Phone: 0300 123 6780  
Email: lhscustomerservice@lancashire.gov.uk  
Your ref:  
Our ref: LHS/CS/3/2016/1203  
Date: 2<sup>nd</sup> February 2017

<b>Proposal:</b>	Replacement of bay window, roof repair, replacement windows and door, creation of parking space to front.
<b>Location:</b>	85 Regent Street Waddington
<b>Grid Ref:</b>	372807 - 443932

Ground Floor Plan

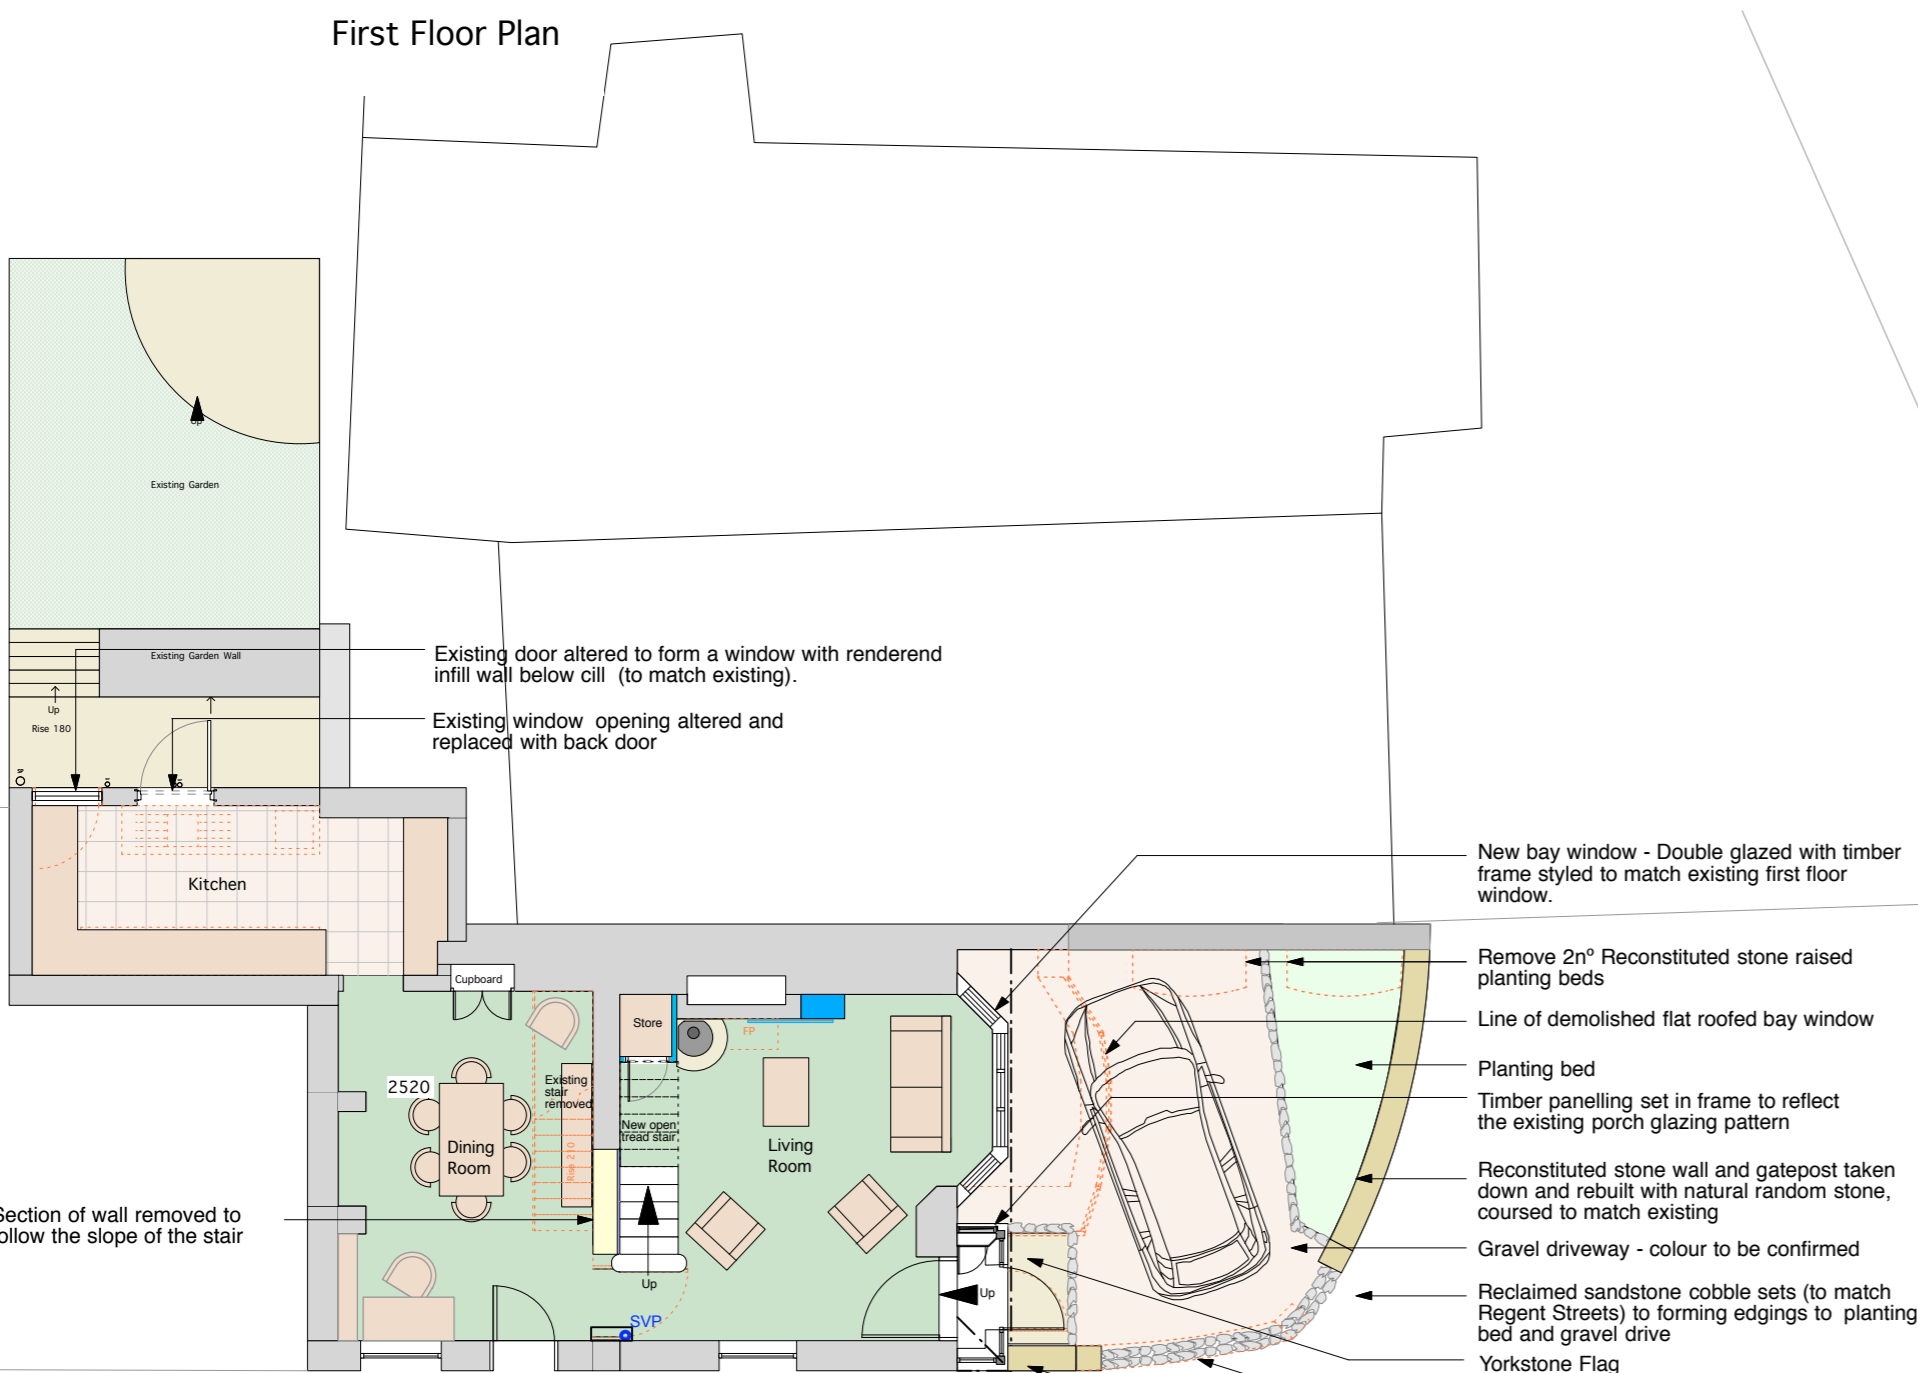
The Highway Development Control Section does not have any objections in principle to the proposed replacement of bay window, roof repair, replacement windows and door, creation of parking space to front, providing the sight lines fronting the parking area can be protected under condition.

1. Before the car parking area hereby permitted becomes operative, the land within 2m of the back edge of the carriageway shall be maintained thereafter, free from obstructions such as walls, fences, trees, hedges, shrubs, ground growth or other structures within the splays in excess of 1.0 metre in height above the height at the centre line of the adjacent carriageway. Reason: To ensure adequate visibility at the street junction or site access in the interest of highway safety in accordance with Quality of Development Policy and Transport Policy in the Local Plan.
